**Our Case Number: ABP-313509-22**

**Re:** BusConnects Belfield/Blackrock to City Centre Core Bus Corridor Scheme  
Co. Dublin

Bus Connects Ballsbridge to City Center  
Belfield/Blackrock to City Centre  
Core Corridor Scheme  
Reference No ABP-313509-22  
Submission by Jack and Freeda McEvoy  
83 Nutley Lane.

TYPICAL SECTION W-W  
NUTLEY LANE  
LOCATED ON GA SHEET 23  
DRAWING REF: BCIDC-ARP-GEO\_GA-1415\_XX\_01-DR-CR-0023

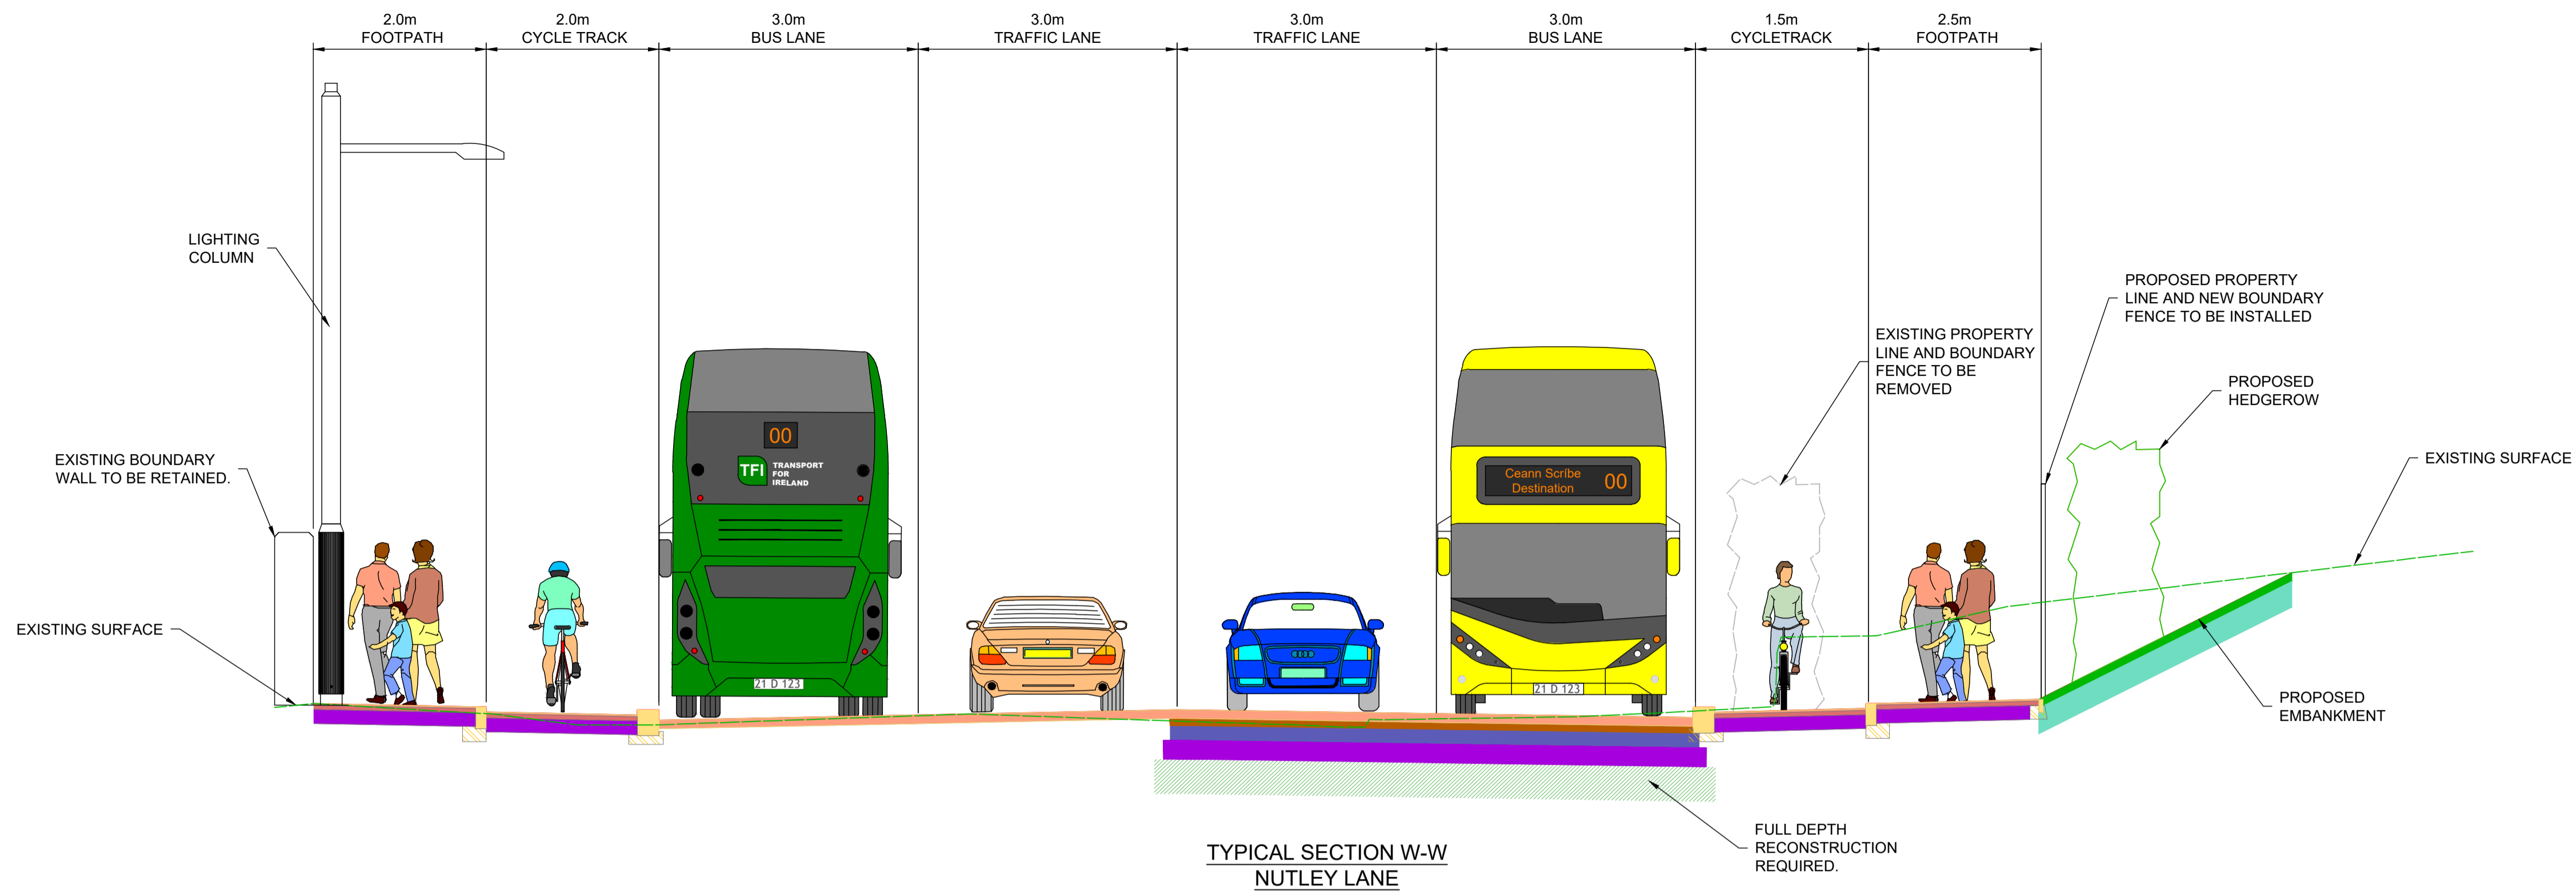
The chosen NTA option ie NL2 ranks least well of six of the options reviewed by the NTA in terms of environmental impact, see direct quote from the NTA below.

Option NL2, involves the removal of at least 80 mature trees and 100 meters of vibrant mature hedgerows along the whole length of Nuley Lane from the Merrion Road end to the Stillorgan Road end . A large section of these hedgerows to be replaced with a "reinforced concrete wall" .

We previously observed that Option NL3 with some minor amendments would significantly reduce the environmental impact by retaining most of the trees while substantially all of the bus traffic objectives of Option NL2.
